**RE: Request for Further Information
Lingard Private Hospital Expansion (SSD-60316710)**

This letter is submitted to the Department of Department of Planning, Housing and Infrastructure in response to the Request for Further Information (RFI) issued on 10 December 2024, relating to SSD-60316710 for the proposed expansion of the Lingard Private Hospital.

3 DA. - PROPOSED SHADOW DIAGRAM - 21 JUNE 1100
Scale 1:400

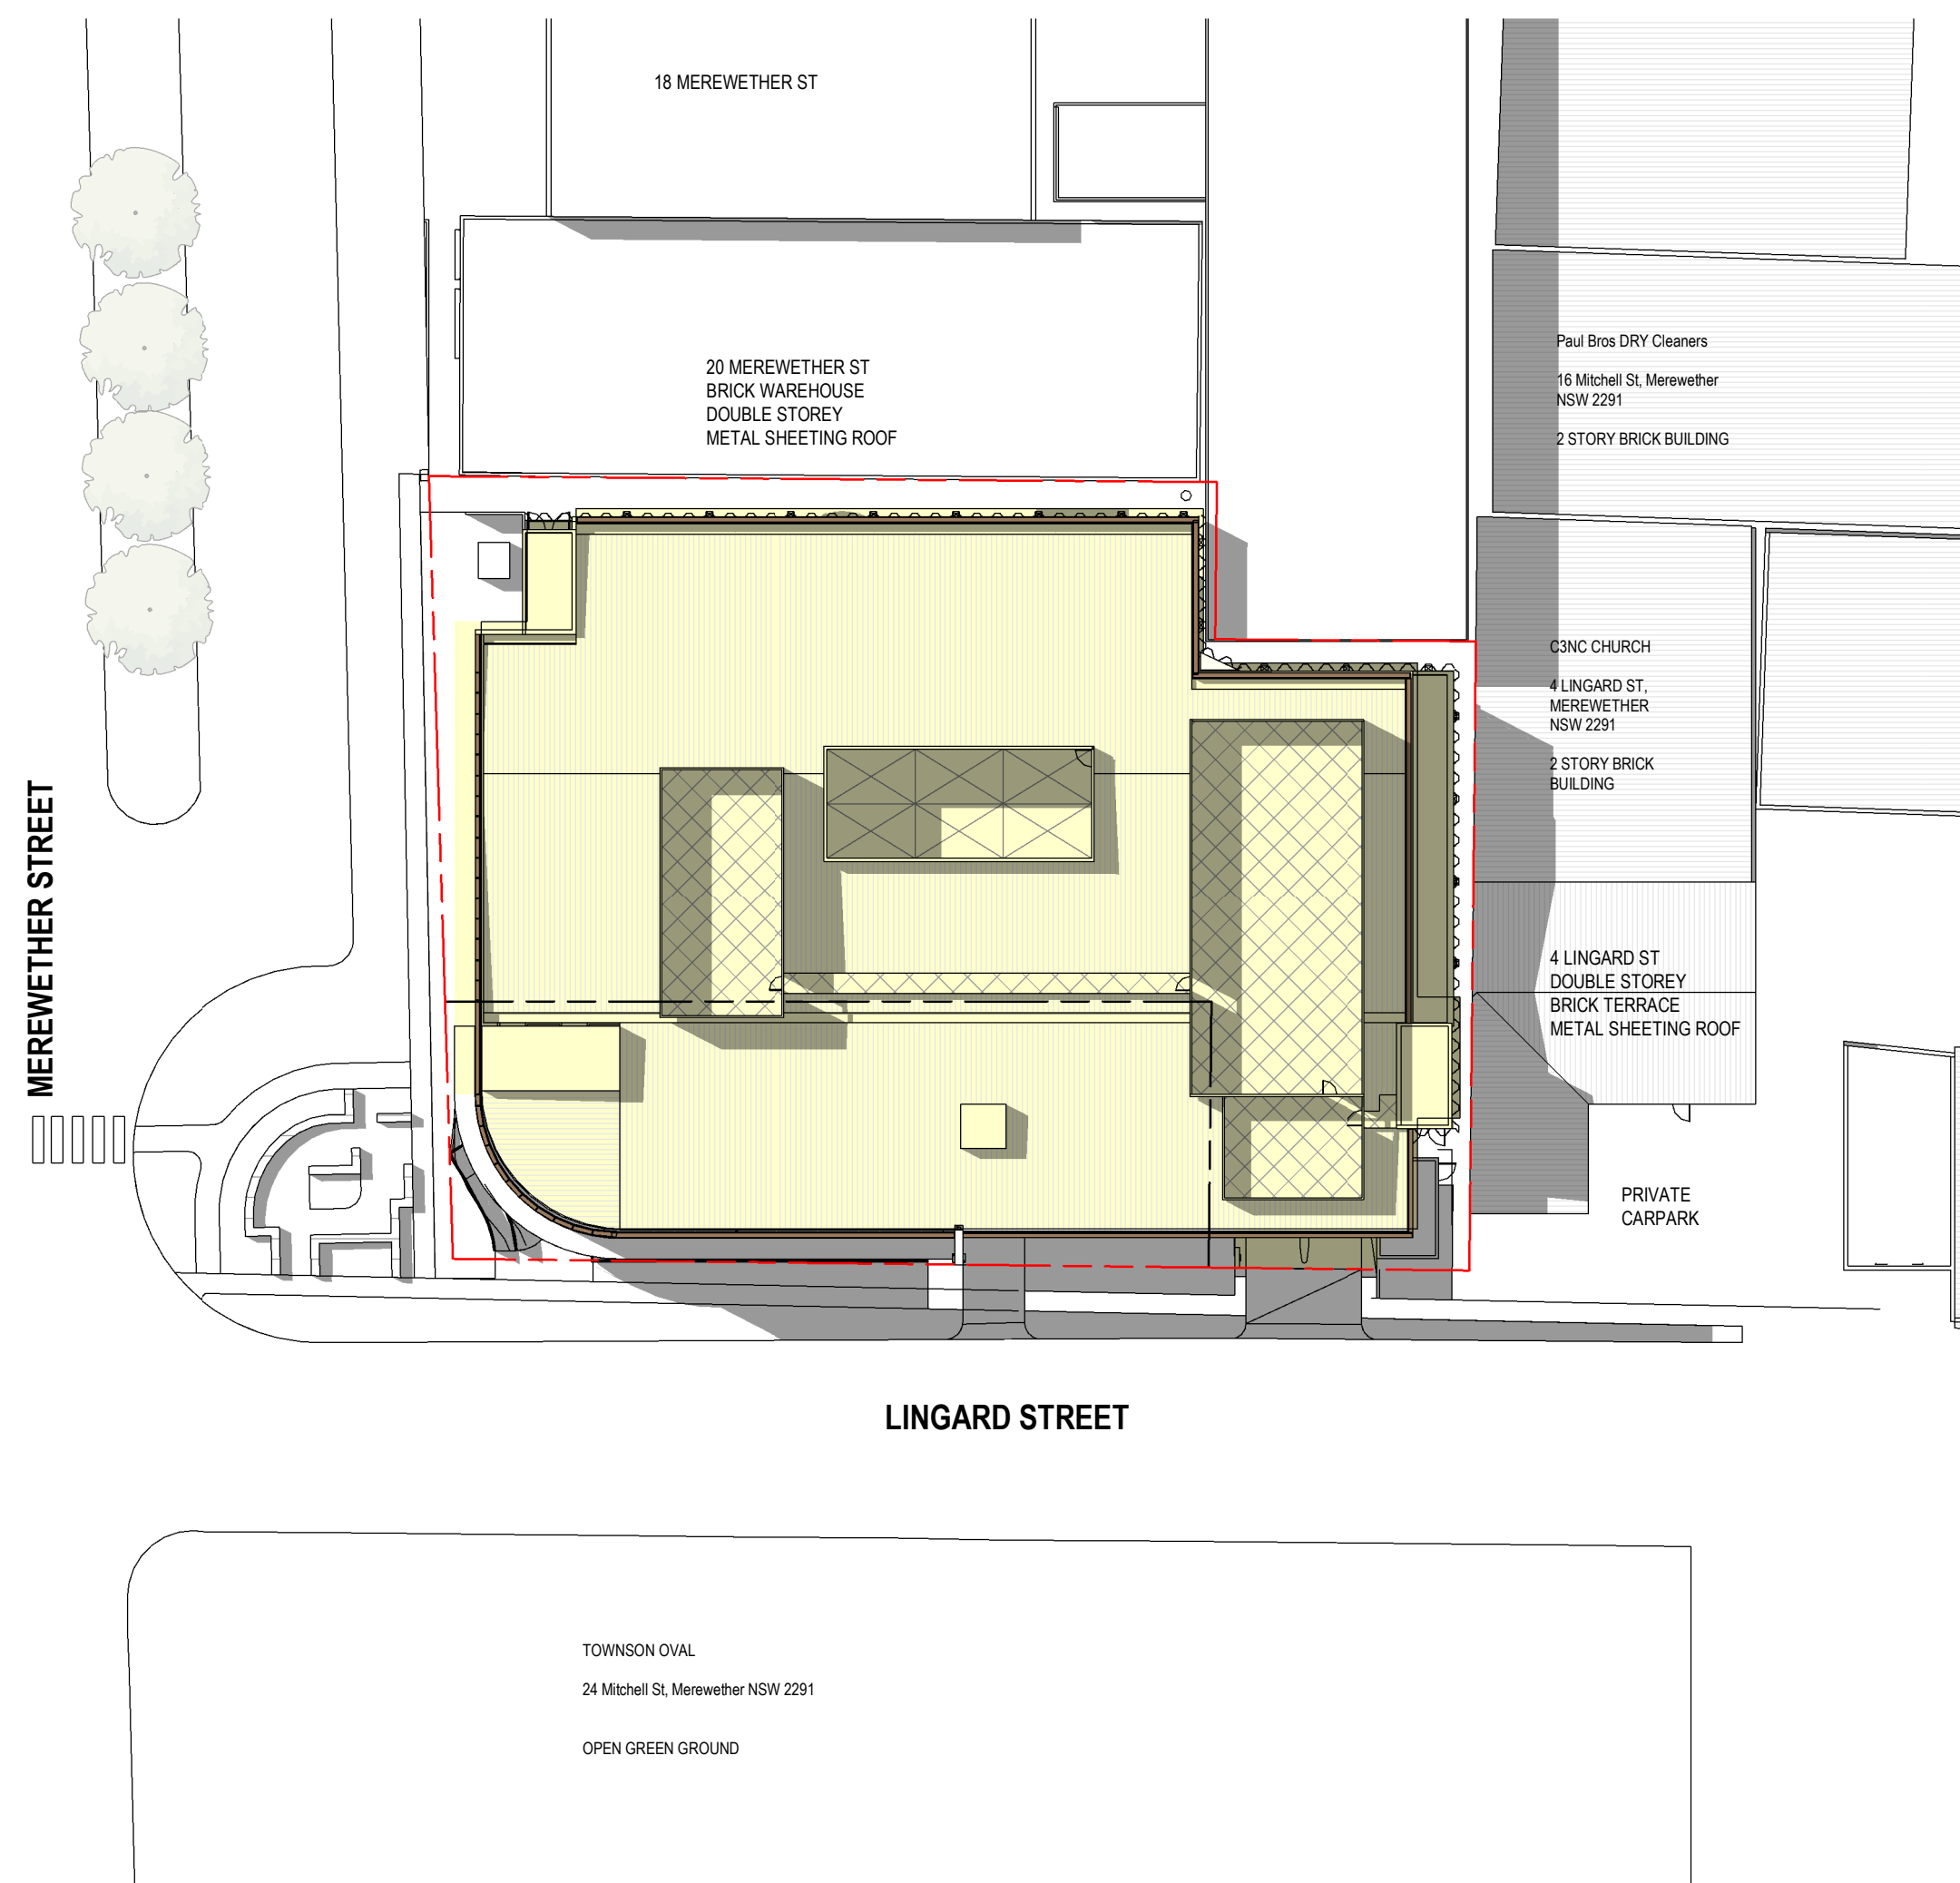
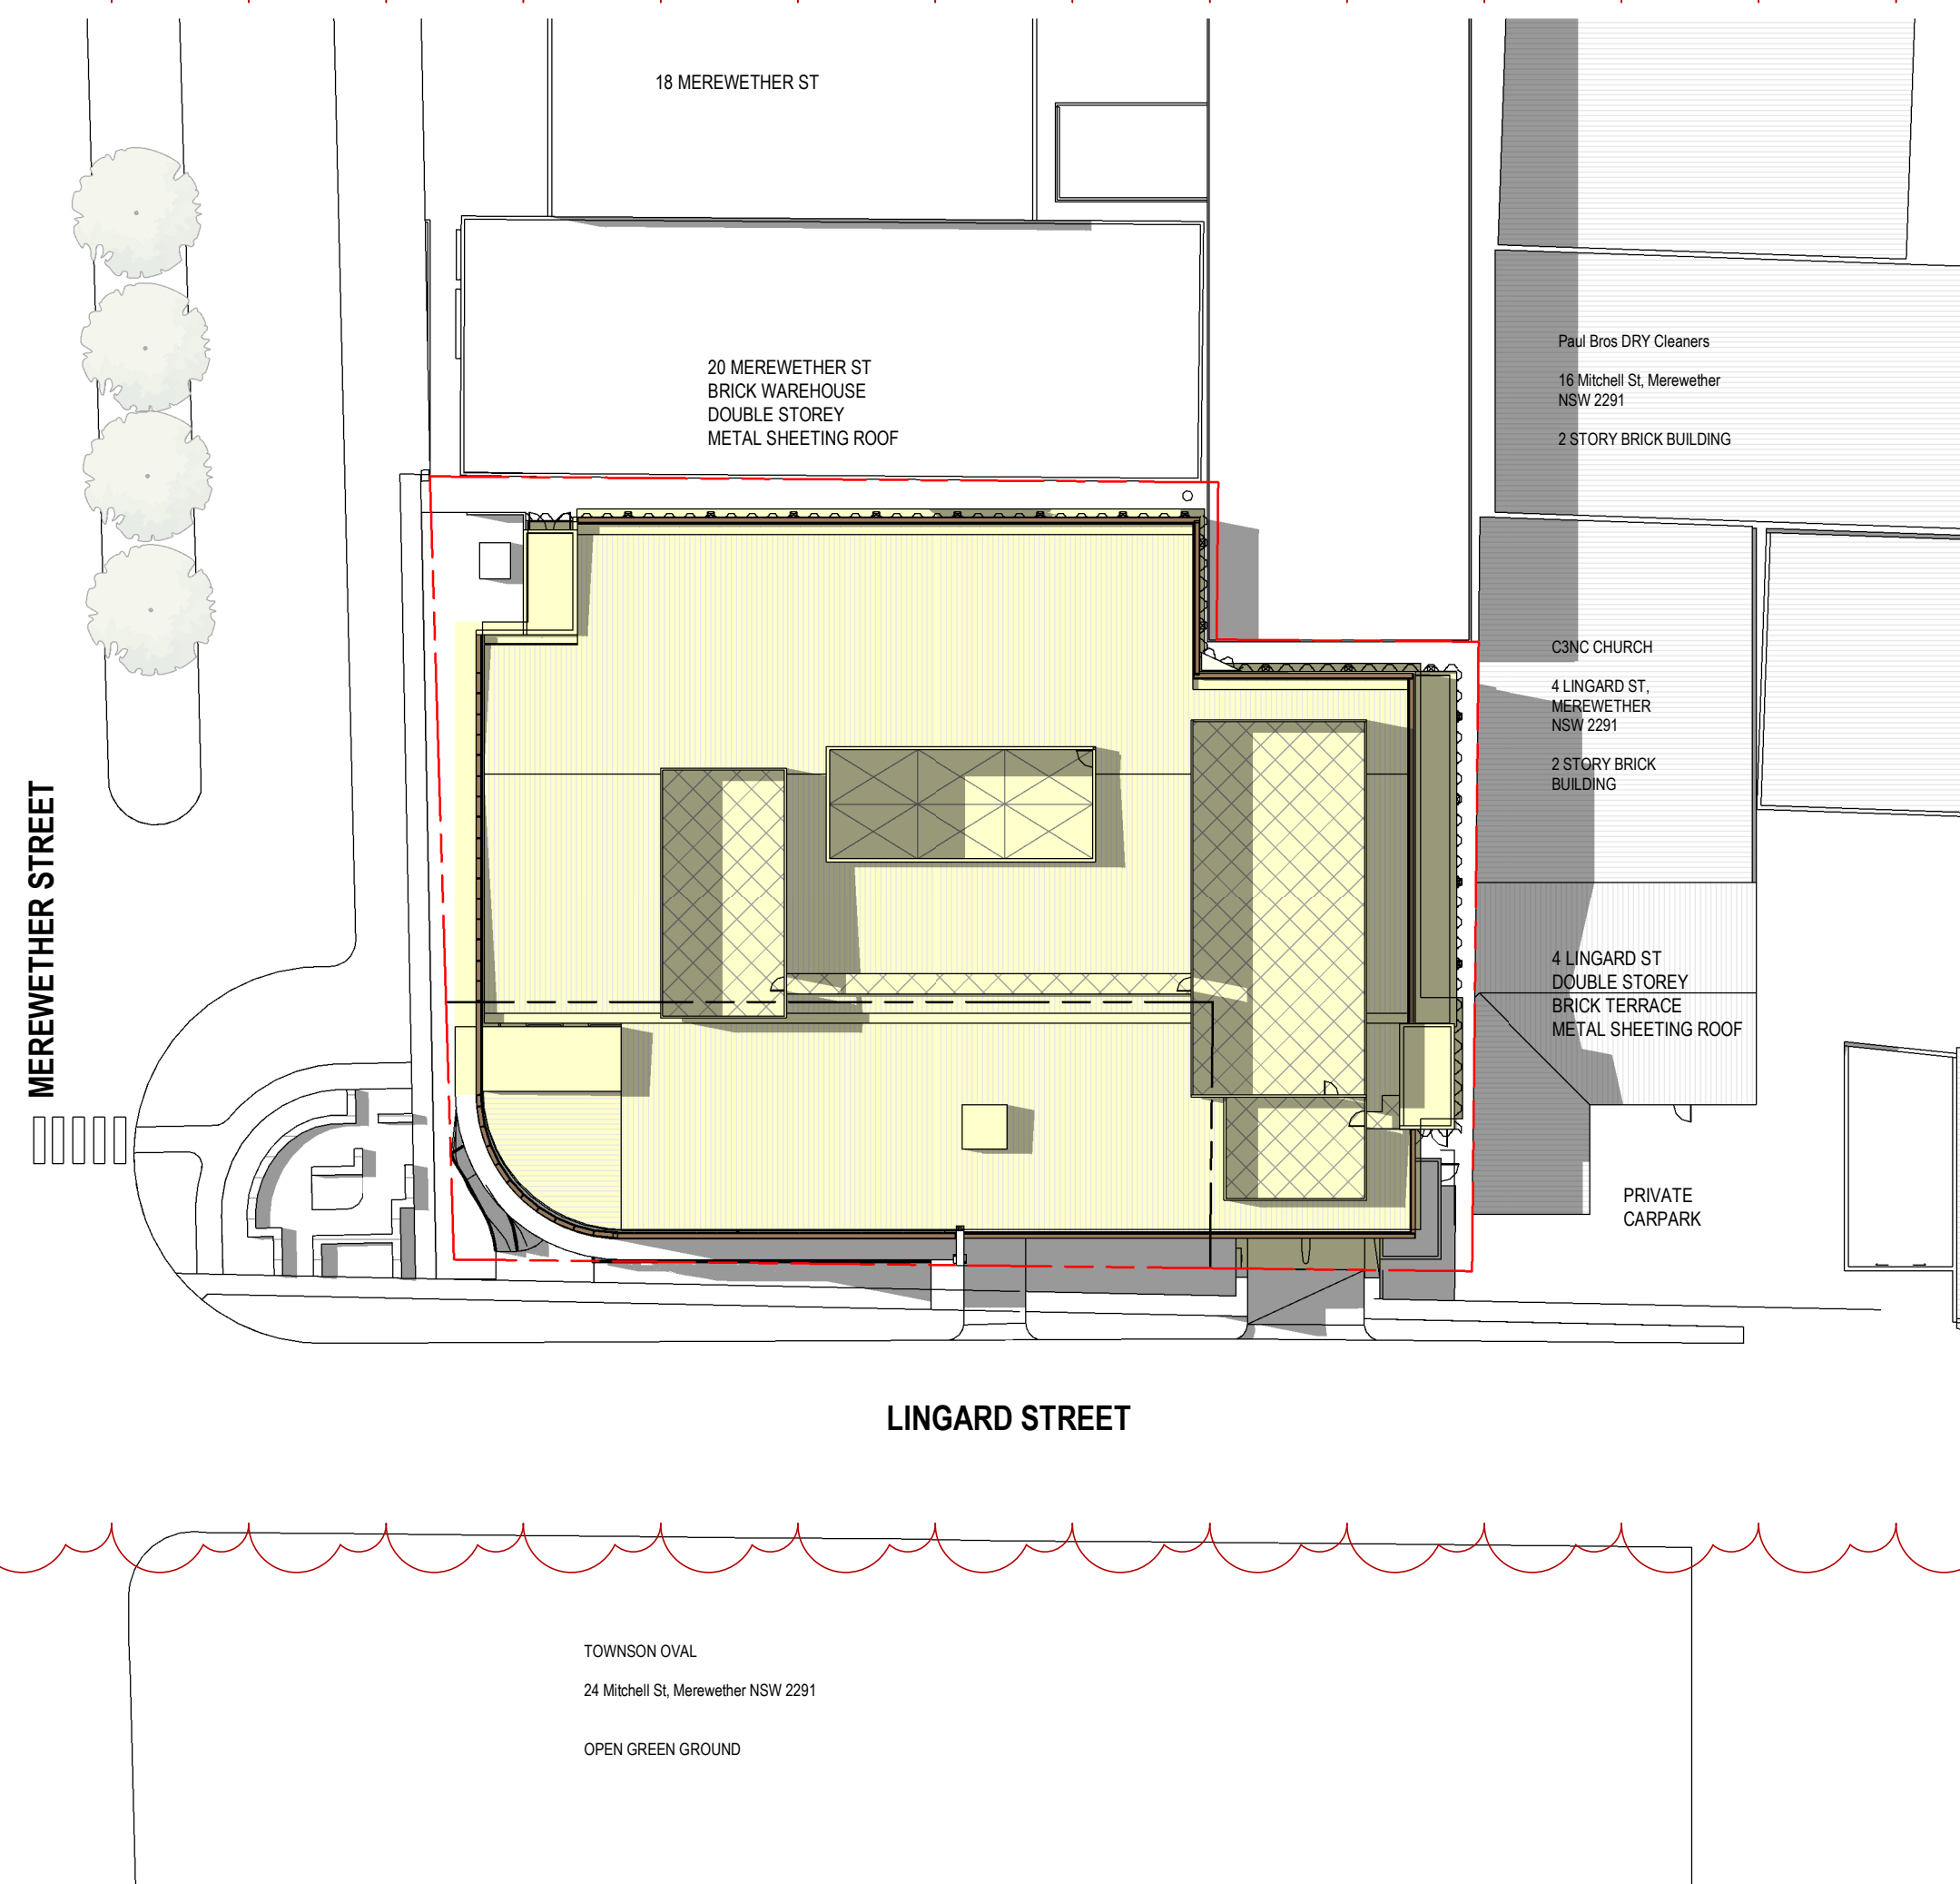
CN's concerns regarding residential amenity remain. The amended architectural plans do not include hourly shadow diagrams or 3D shadow analysis to identify the habitable rooms and private open space of residential properties, as previously requested. The shadow impact to Mitchell Park has not been adequately addressed.

The non-compliant height coupled with reduced setbacks on the eastern boundary of the Hopkins Precinct, exacerbate the amenity impacts. CN recommends the design is amended to reduce the bulk and ensure upper floor levels comply with the setback requirements and maximum building height development standard. CN recommends the applicant is required to submit additional shadow diagrams at hour intervals between 9am and 3pm during the June 21 winter solstice.

Additional shadow diagrams have been provided at Appendix A. The overshadowing of Mitchell Park is minimal, occurring only at 9 AM during winter. The affected area consists of large trees and on-street parking that would naturally be in shadow. The proposal ensures ample daylight reaches the trees and surrounding area at all other times.

The amended shadow diagrams include percentage calculations for the surrounding residential dwellings and confirm compliance. The most significant impact is on 11 Merewether Street in the afternoon; however, the existing shadow diagrams show that this is also the present state, refer to Figure 1 & 2 below. In the previous iteration of plans the second level wall was also setback further from this boundary.

Overall, the proposed height variation does not result in any unreasonable adverse impacts on neighbouring properties in terms of bulk, scale, overshadowing, or privacy. The minor exceedance is justified by the functional necessity of the affected building elements and their limited contribution to the overall form, ensuring a well-balanced outcome that meets the intent of the planning controls while supporting high-quality urban design. Additional shadow diagrams are provided at Appendix A.
